From: Maria Tomalova
Sent: 19 July 2019 10:52
To: Planning.Responses
Subject: FW: BR/63/19/PL, 15-17 Kew Gardens, Bognor Regis
Attachments: 180037_02B_blockplan-A3 SHEET.pdf; 180037_03A_proposedsiteplan-A1 SHEET.pdf; 180037_04A_proposedplansandelevationsP1andP2-A1 SHEET.pdf; 180037_05A_proposedstreetscenes-A1 SHEET.pdf; 180037_07_proposedplansandelevationsP3andP4-A1 SHEET.pdf; 180037_08_proposedplansandelevationsP5andP6-A1 SHEET.pdf

Technical housing standards – nationally described space standard

Title:-
Proposed Floor Plans & Elevations (P1&P2)

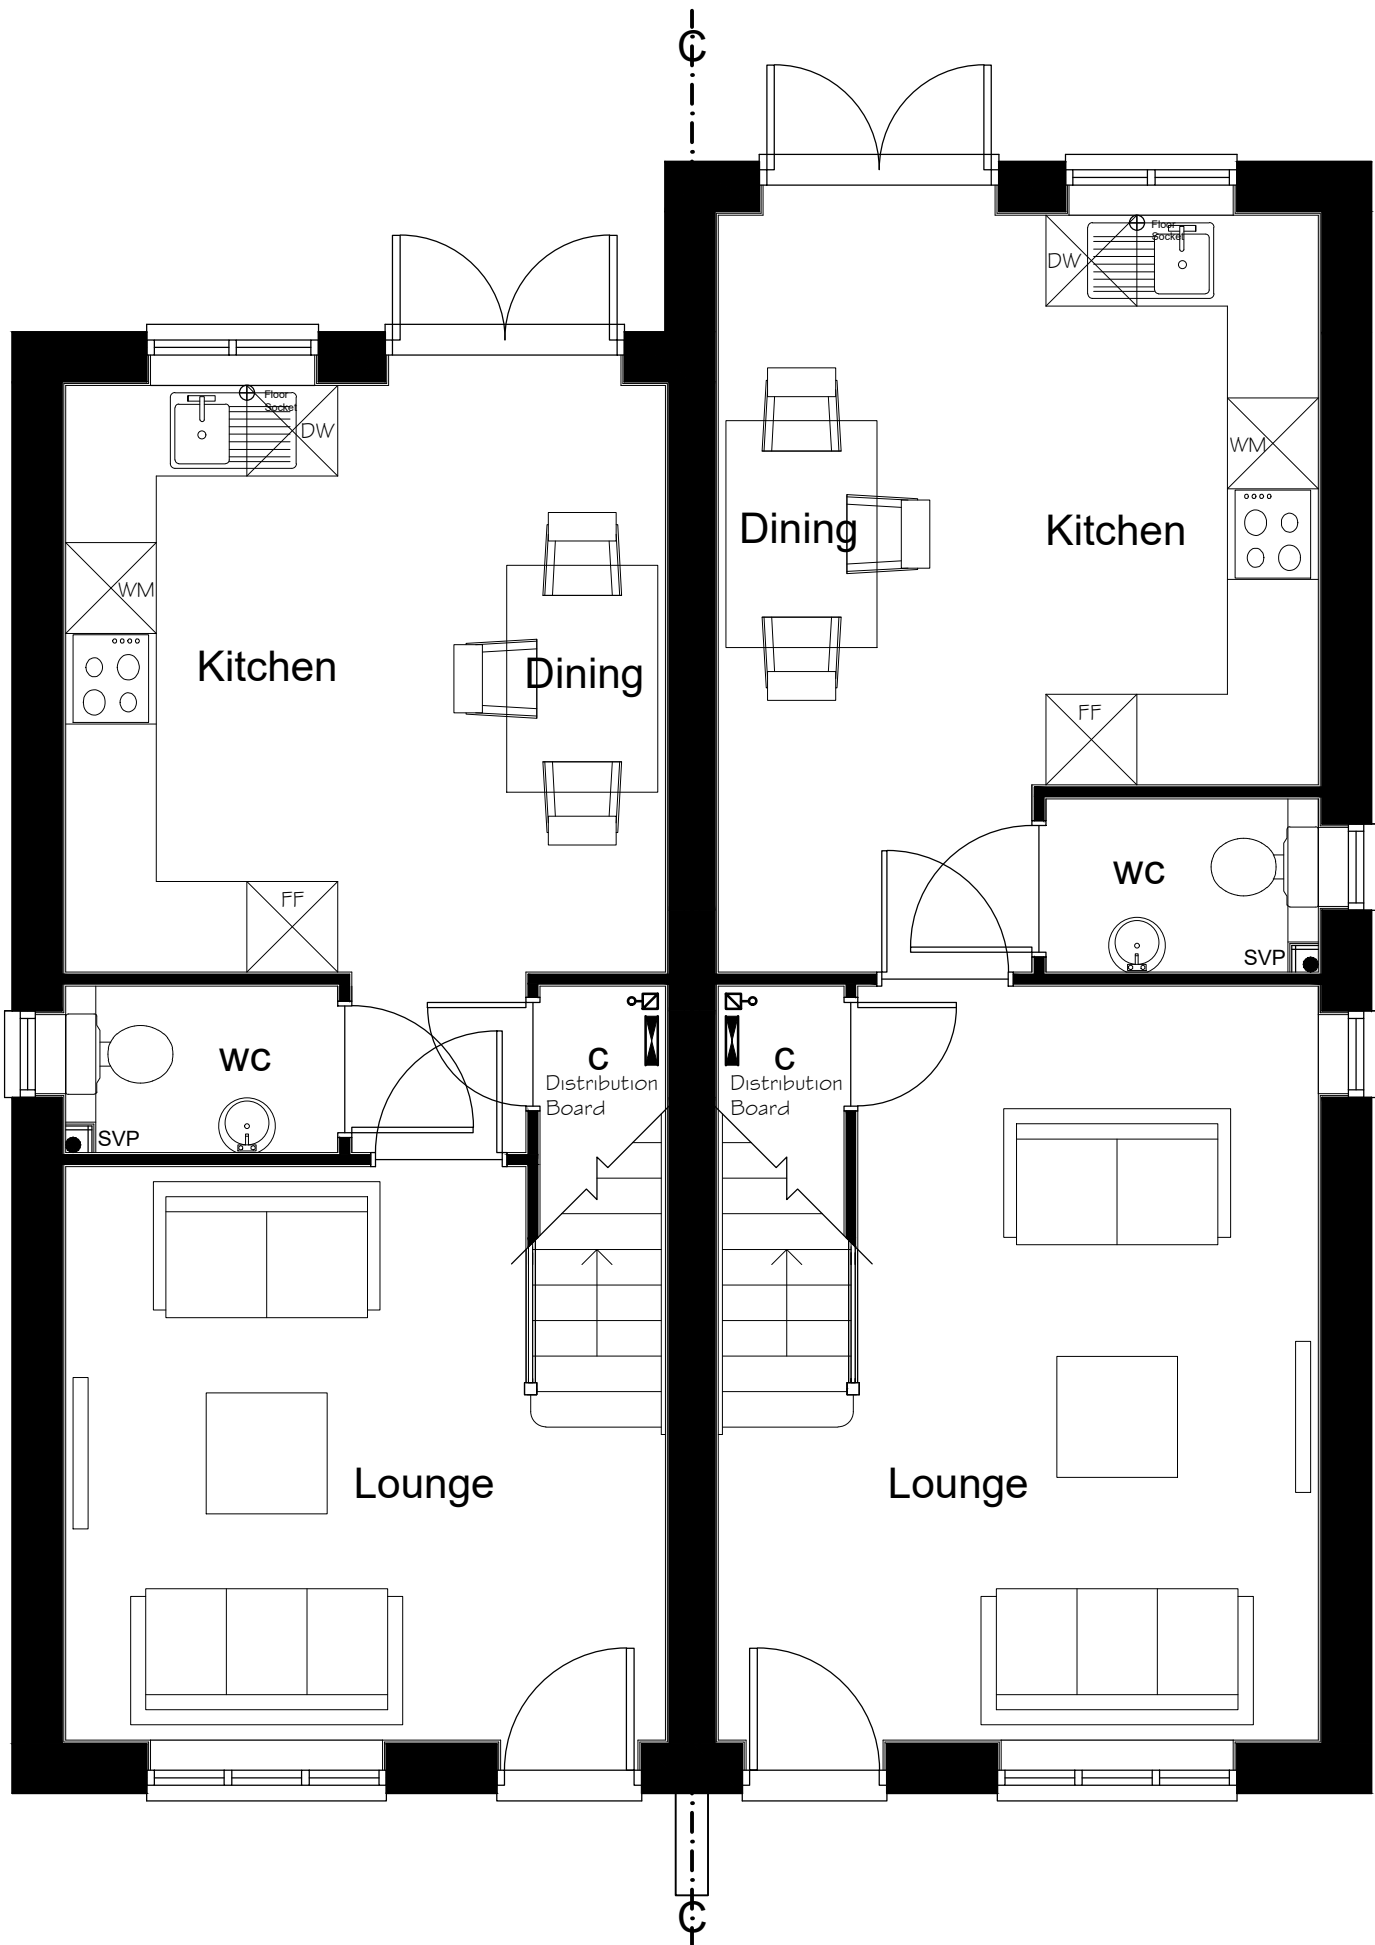
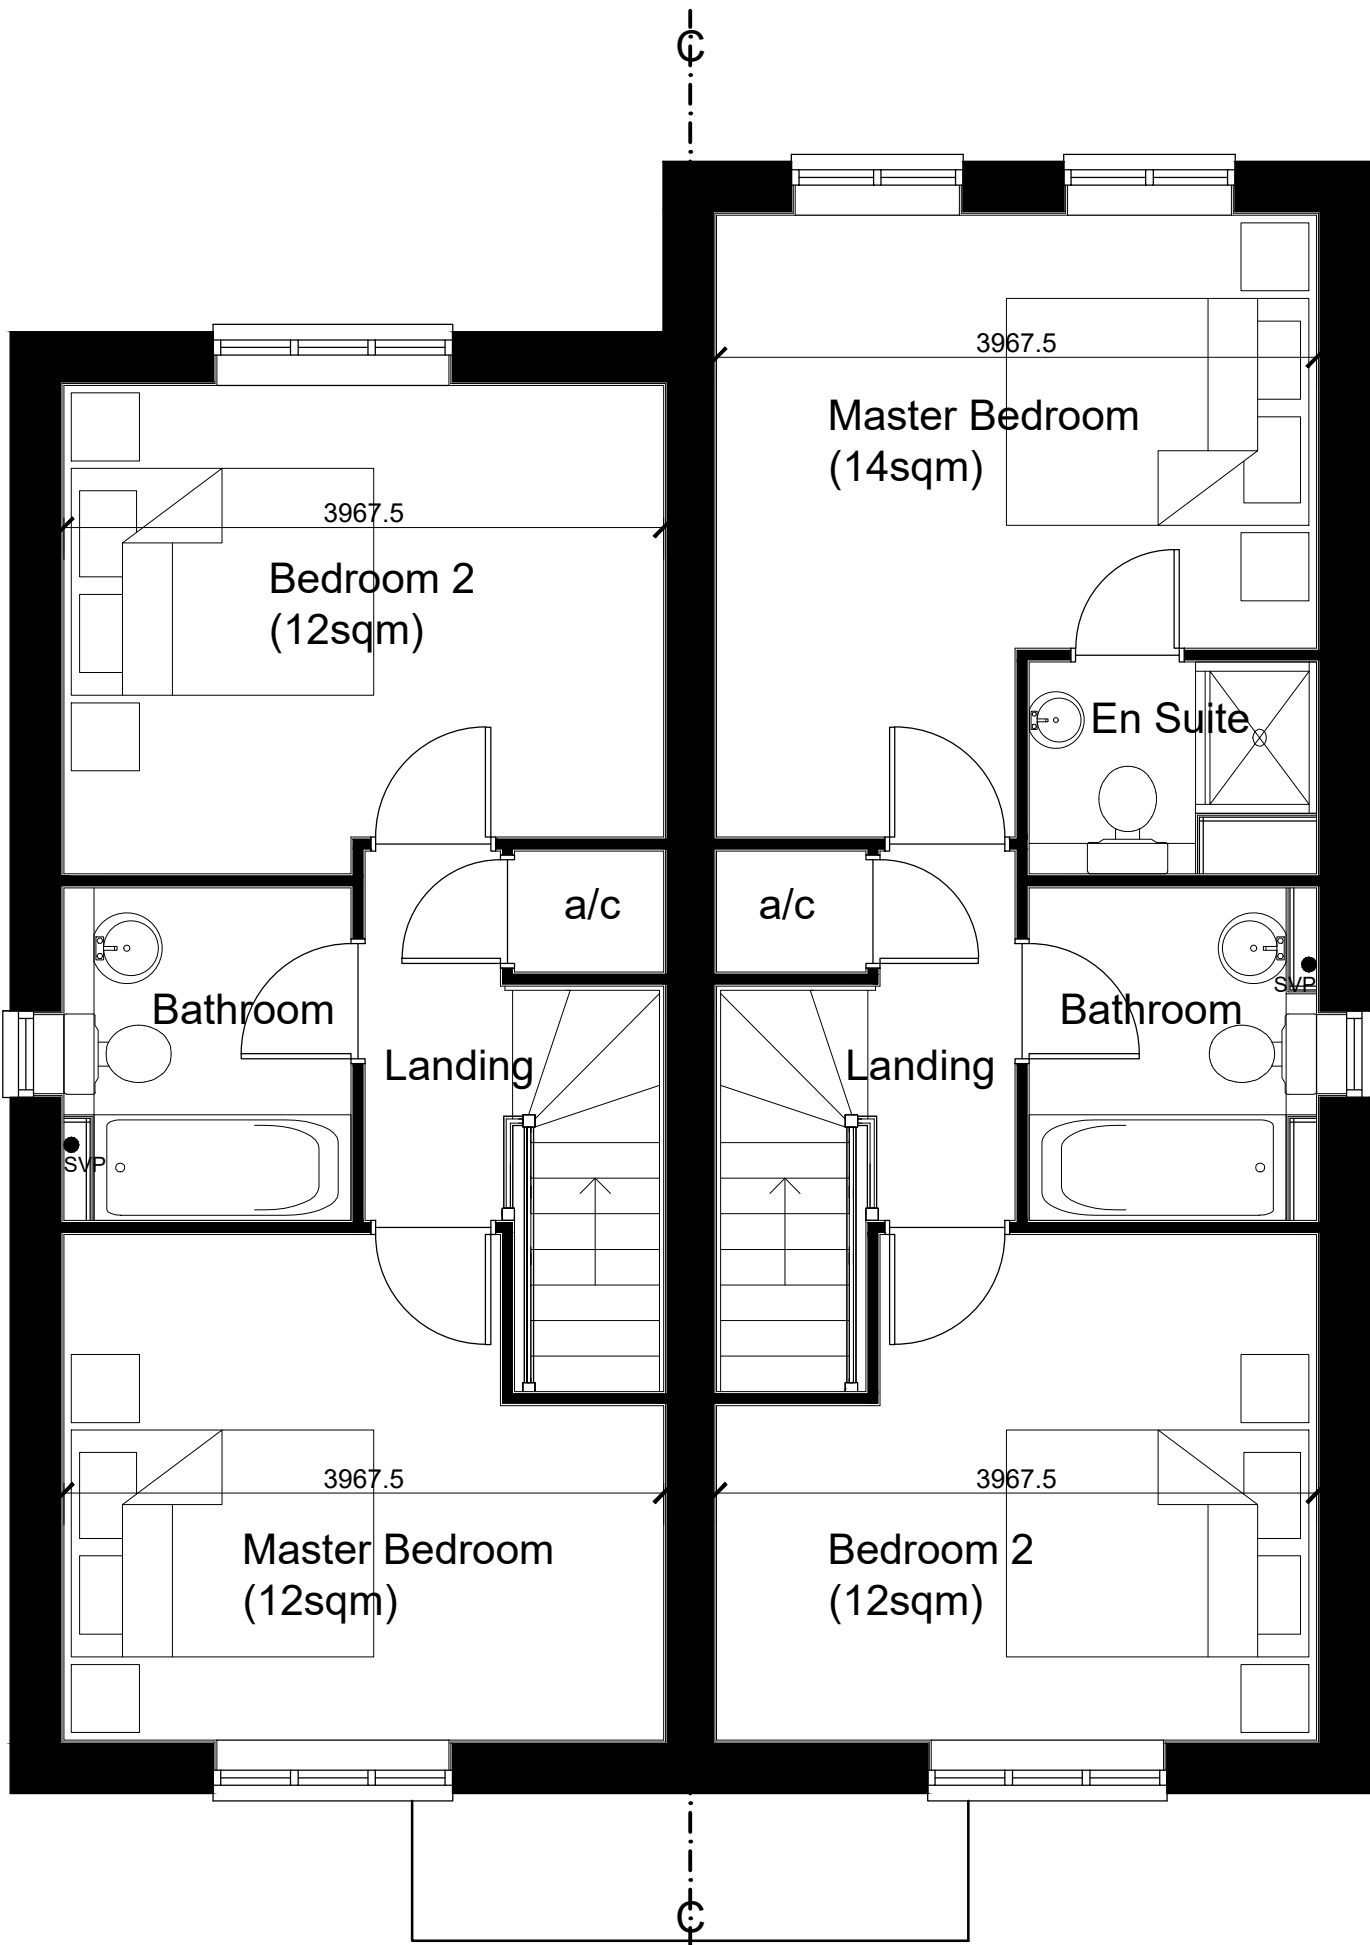
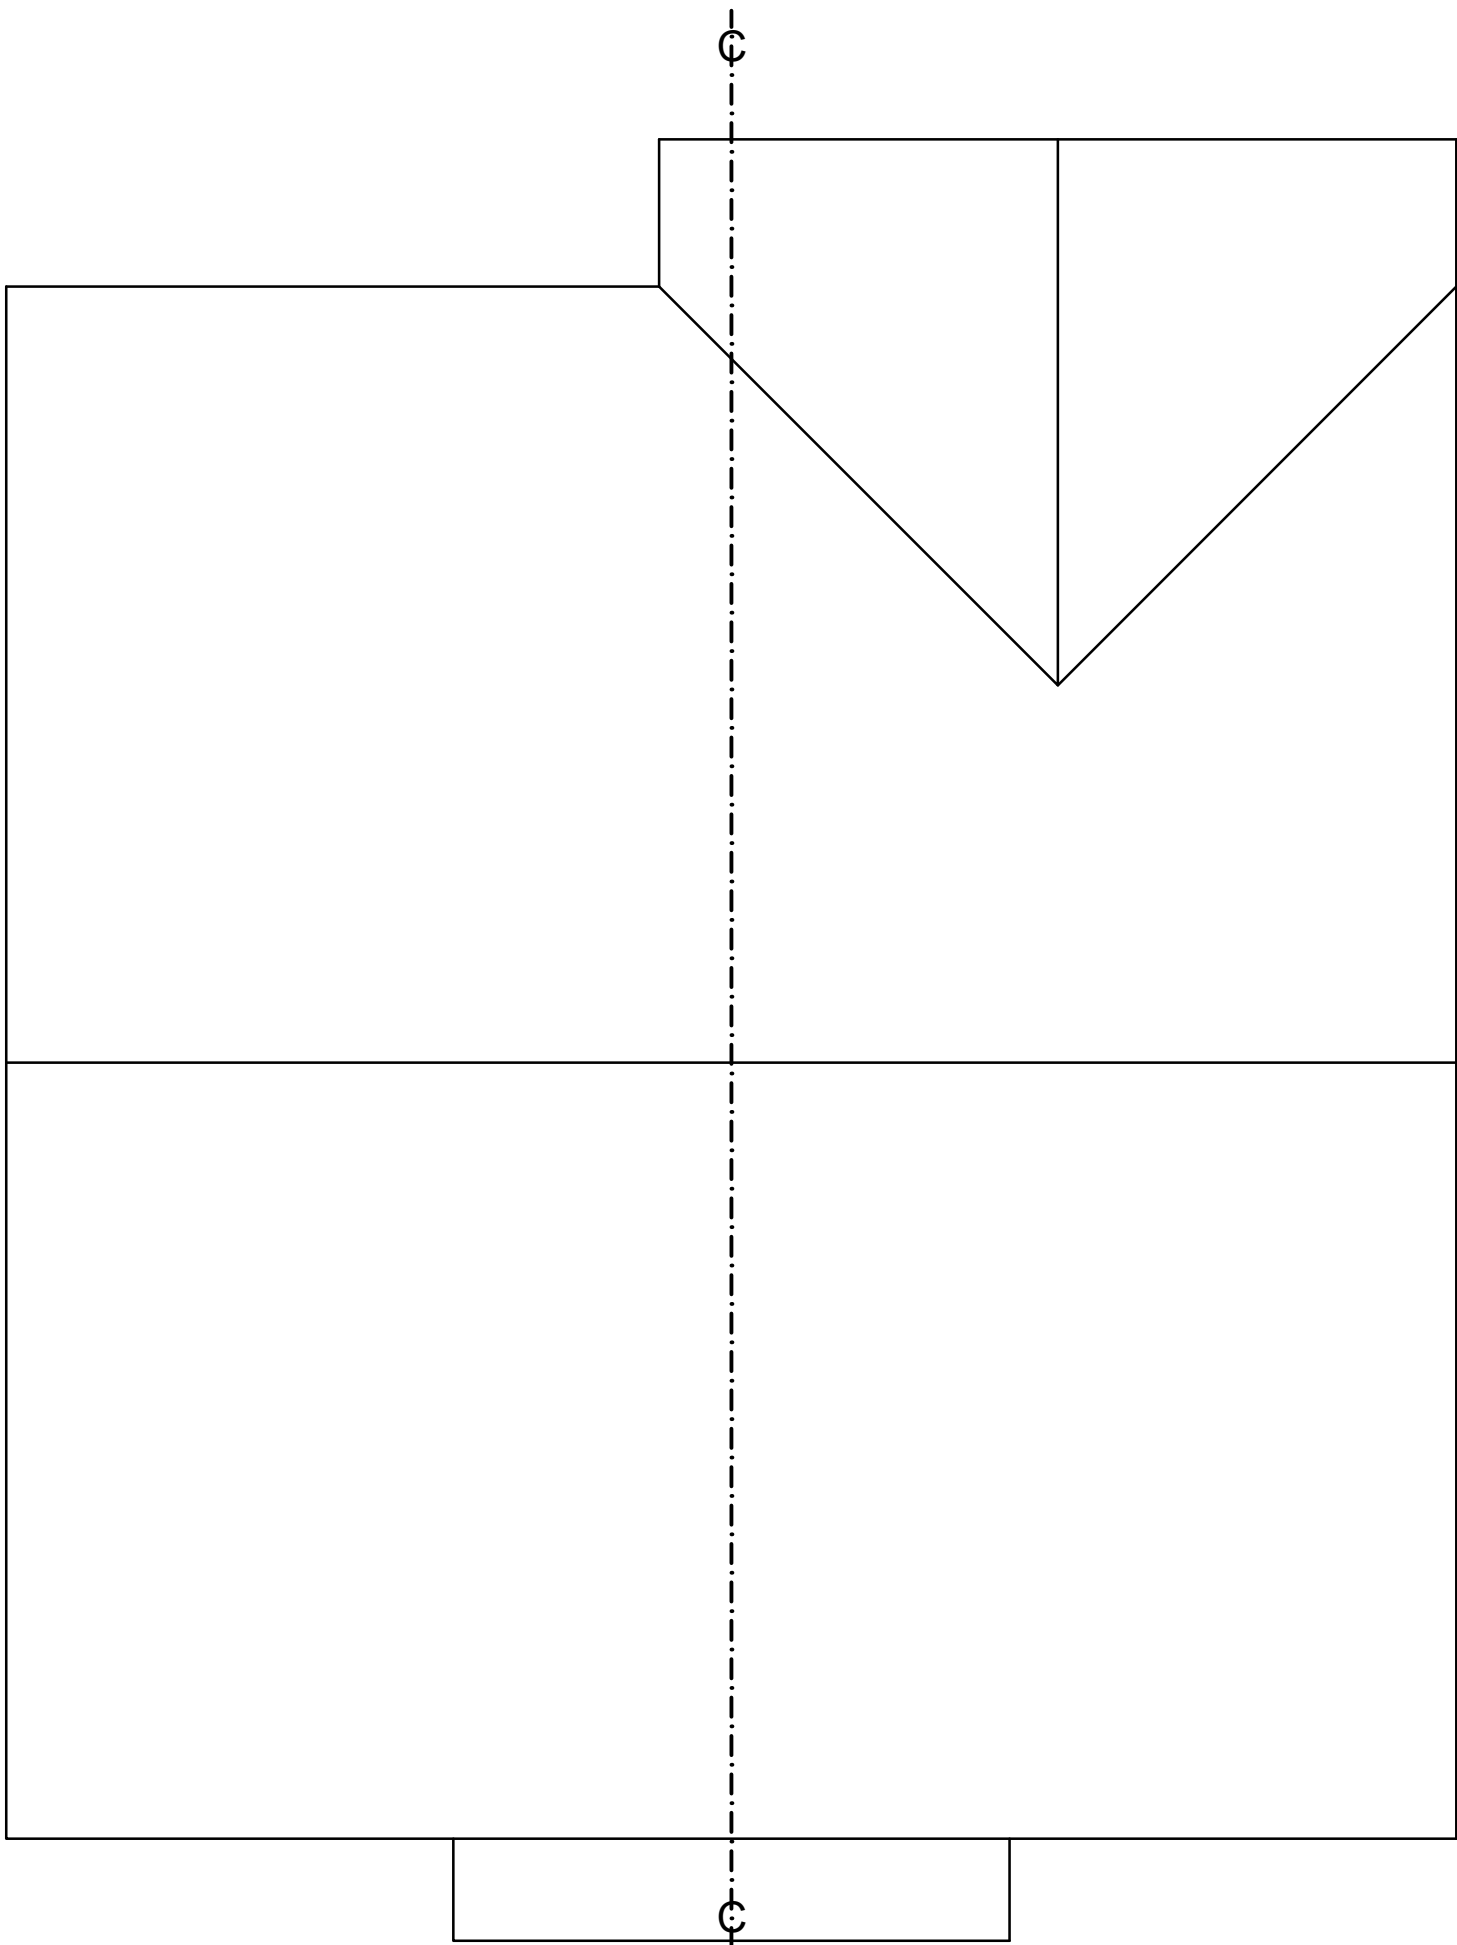
Please see below the min requirement for the floor space.
I am afraid your proposal would not comply with.

- c. in order to provide one bedspace, a single bedroom has a floor area of at least 7.5m² and is at least 2.15m wide
- d. in order to provide two bedspaces, a double (or twin bedroom) has a floor area of at least 11.5m²
- e. one double (or twin bedroom) is at least 2.75m wide and every other double (or twin) bedroom is at least 2.55m wide

2bed , 2storey dwellings

min 79 square metres

It is rather difficult to comment your drawings, since I do not have a tool to measure it on the screen
And I am not sure the size of some bedroom comply with the standard (min width 2.15m, min floor space for 1 bed
7.5 square metres.

I confirm that plots 1 and 6 are now 2 bed 3 person houses at 72sqm. Plots 2 and 5 are now 2 bed 4 person houses at 81sqm. Plots 3 and 4 are now 3 bed 4 person houses at 87sqm. All the bedroom areas and widths now all comply. On this basis all units now comply with the standards.
